Date: 24th February 2021

Pre-Application Advice

Construction of 8 semi-detached houses consisting 2 and part 3 storey homes, consisting two and three bedroom homes with associated access, parking and, landscaped areas

The land adjoining former Rising Sun public House 351 Chichester Road Bognor Regis PO21 5AN

3 Front Elevation
1 : 50

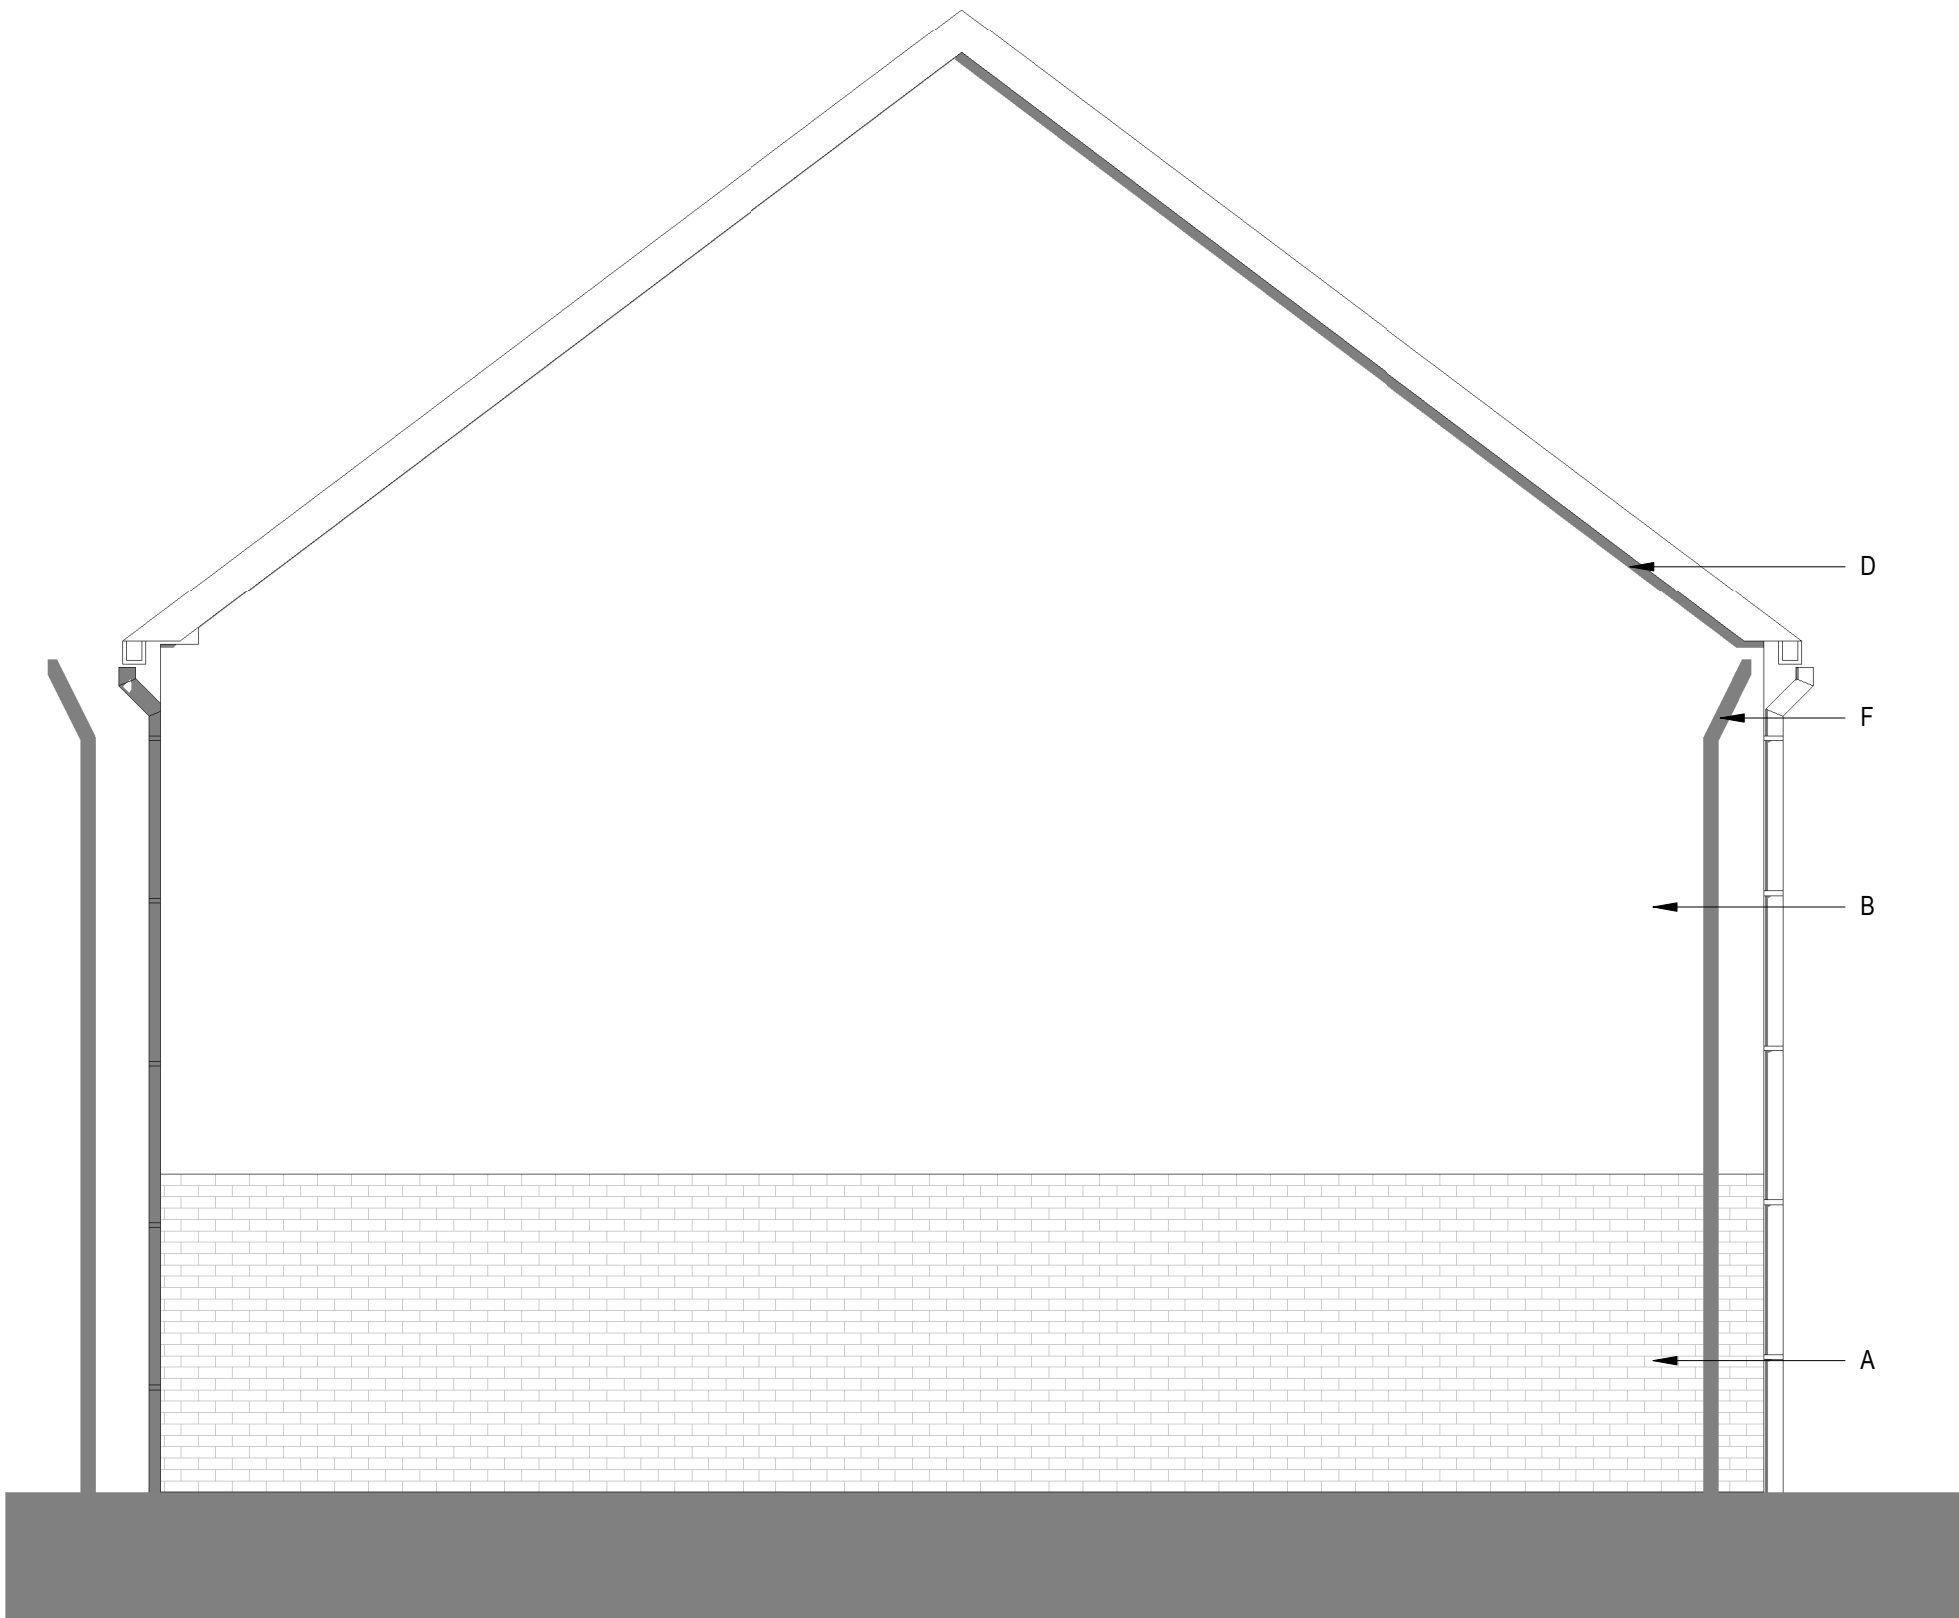
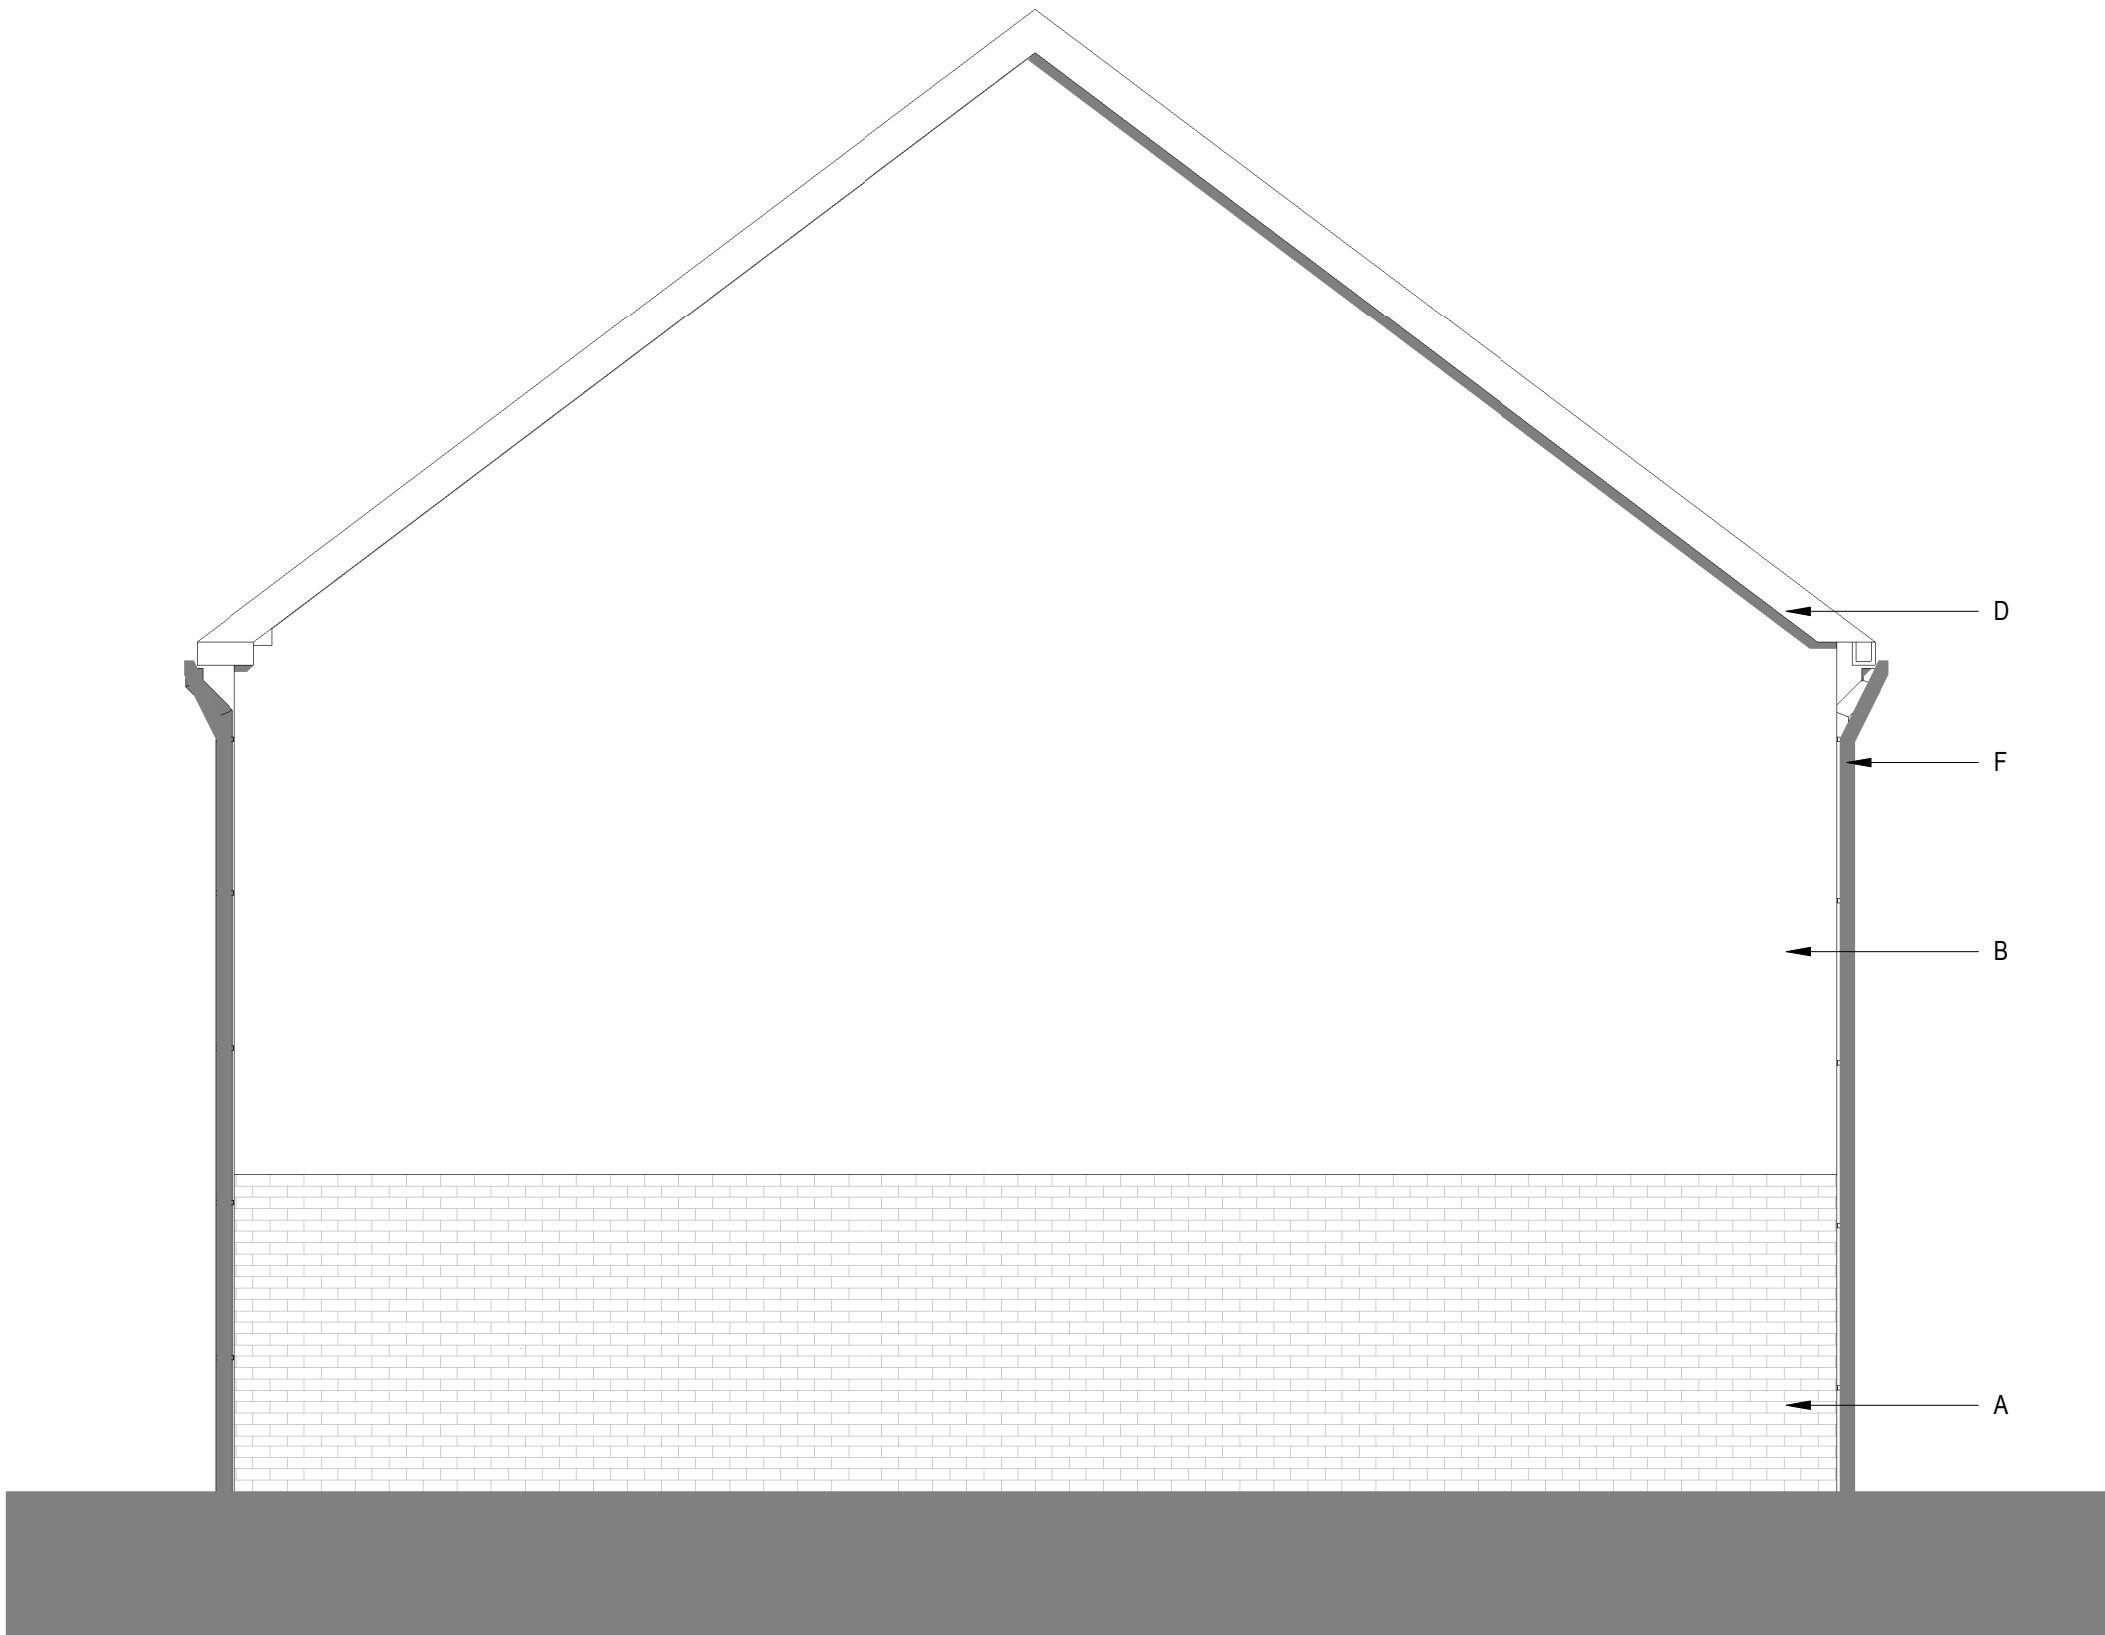
The site forms the parking space and a rear garden of the former Rising Sun PH (now Tesco Express). The proposal would contain 4 pairs of semidetached properties. The 2 pairs to the north from Tesco would be 2 storey with a simple gabled roof, oriel window at the first floor level to the front and French doors one French window to the rear with rather small bedroom windows at the first floor level.

A counterpart of the semis situated along Chichester Road would be facing to the road with its large gabled elevation and a pair of small oriel windows at the first floor level within a close distance to the road whilst the houses along Chichester Road are well set back with eaves to the front. It is considered that it would not be an appropriate addition to the existing streetscene and fails to respect dwellings in the vicinity. The proposed 2 pairs of semis to the rear of Tesco (garden) would have a habitable roof with dormers to the front and rooflights to the rear and a large flat crown on the top of the roof. These houses would not be visible from the street view so they would not have an unacceptable impact on the street scene.

2 Proposed Block Plan
1 : 500

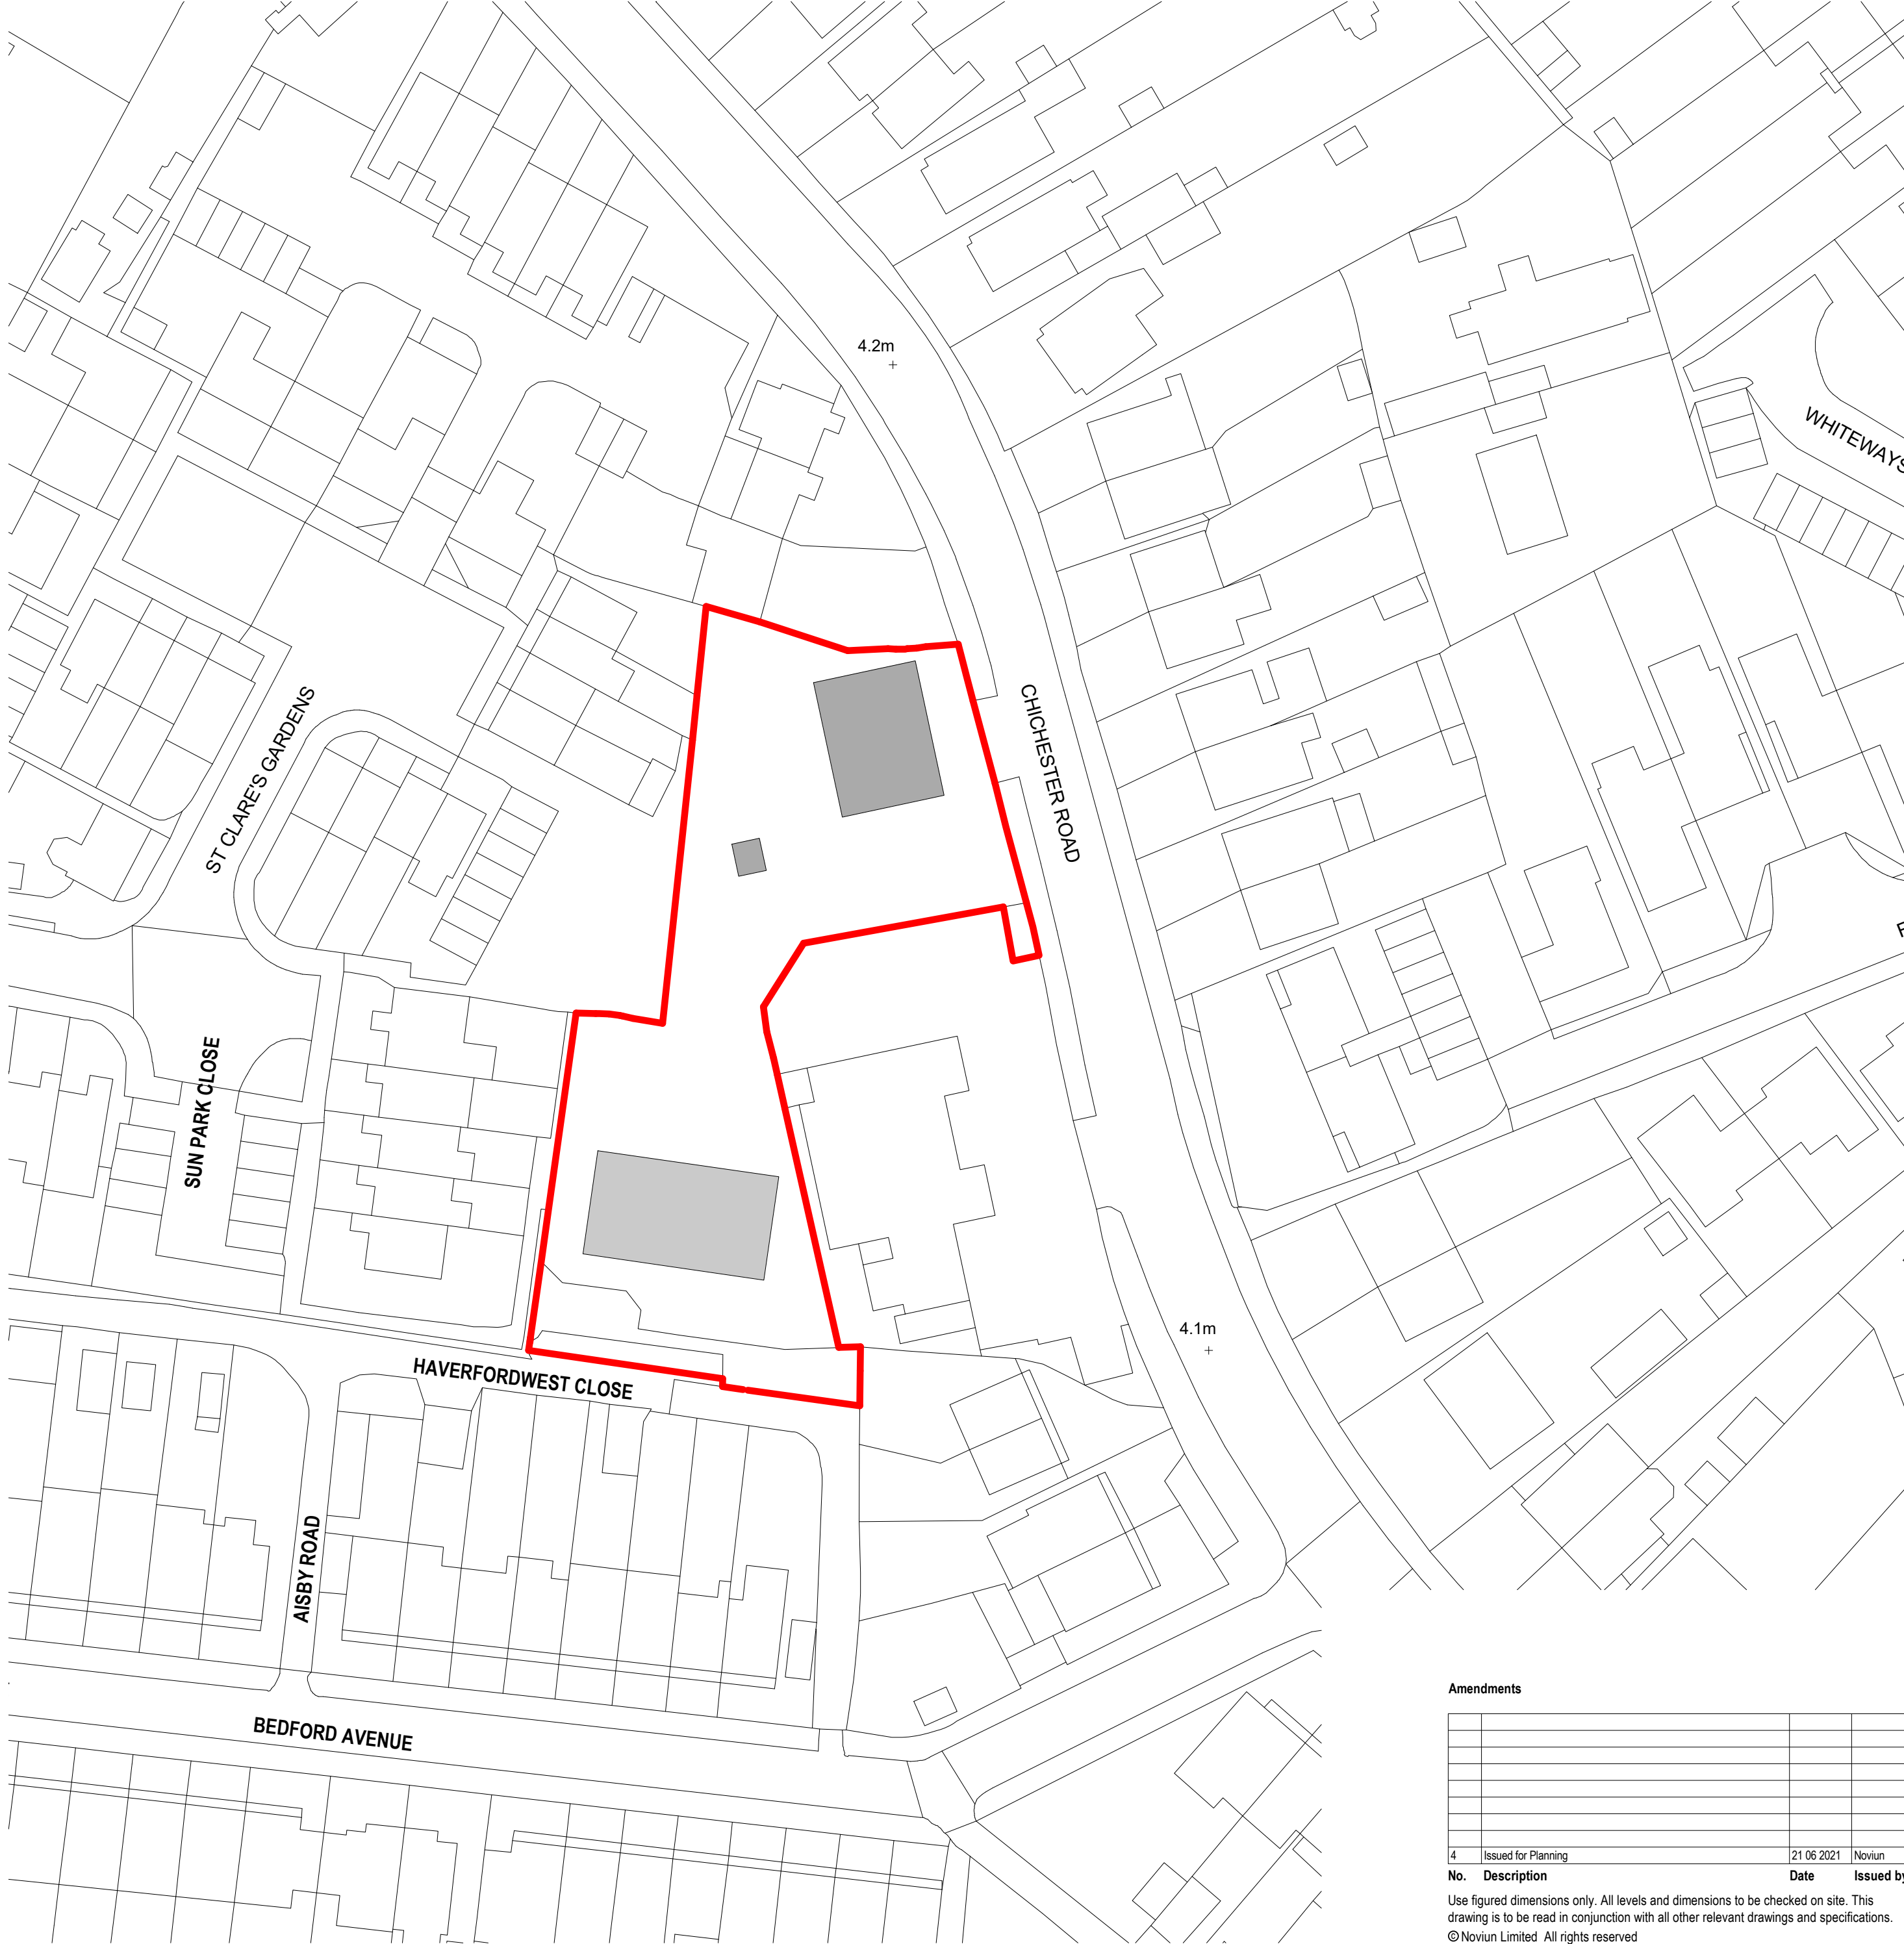
There would be an awkward relationship between the proposed pair of semis situated at the parking area and an existing end terrace property to the north (No 359 Chichester Road) due to the position and proximity of the proposed dwellings facing to the private area of the enclosed front garden with their first floor habitable windows within a distance of 3-5m from the boundary wall of No 359 resulting in an adverse impact on occupiers of this property by way of overlooking and overbearing.

The position of No 04 is rather questionable given an existing large tree along the western boundary which would require considerably larger space than that shown on the site plan.

The proposed No 08 would expose its considerably large flank elevation to the rear of terrace (Nos 28,26) along Sun Park Close within a distance of 10-12m resulting in an adverse impact on living conditions of occupiers of these dwellings, limiting their outlook and causing an overbearing feel of a substantial building in close proximity to their rear gardens.

The size of the existing plot would not allow for private garden of a suitable size to serve proposed dwellings; the 'rear' gardens of Nos 01 and 02 would be 2.5-3metres deep. Only two dwellings' rear gardens would reach the appropriate size and shape of the outdoor amenity space. Any application would need to include a Landscaping Plan to ensure the outdoor external space would be suitably high quality and enclosed/private, and showing proposed boundary treatments.

The site plan shows 17 parking spaces what would satisfy the requirement of the above standard. Electric vehicle charging points at a rate of 1 charging point per house with a garage or parking space should be provided, as per the ADC Parking SPD. In terms of cycle parking, ADC Parking Standards require 1 cycle space for a 2 bed house to be provided on-site. Cycle storage should be undercover, secure, and easily accessible to occupants.

In the event of an application being submitted the layout of the dwellings should be re-considered with separation distances to neighbouring properties to ensure that the proposals would not result in harmful overbearing, overlooking/loss of privacy, loss of outlook to neighbouring properties and discomfort to the future occupiers.
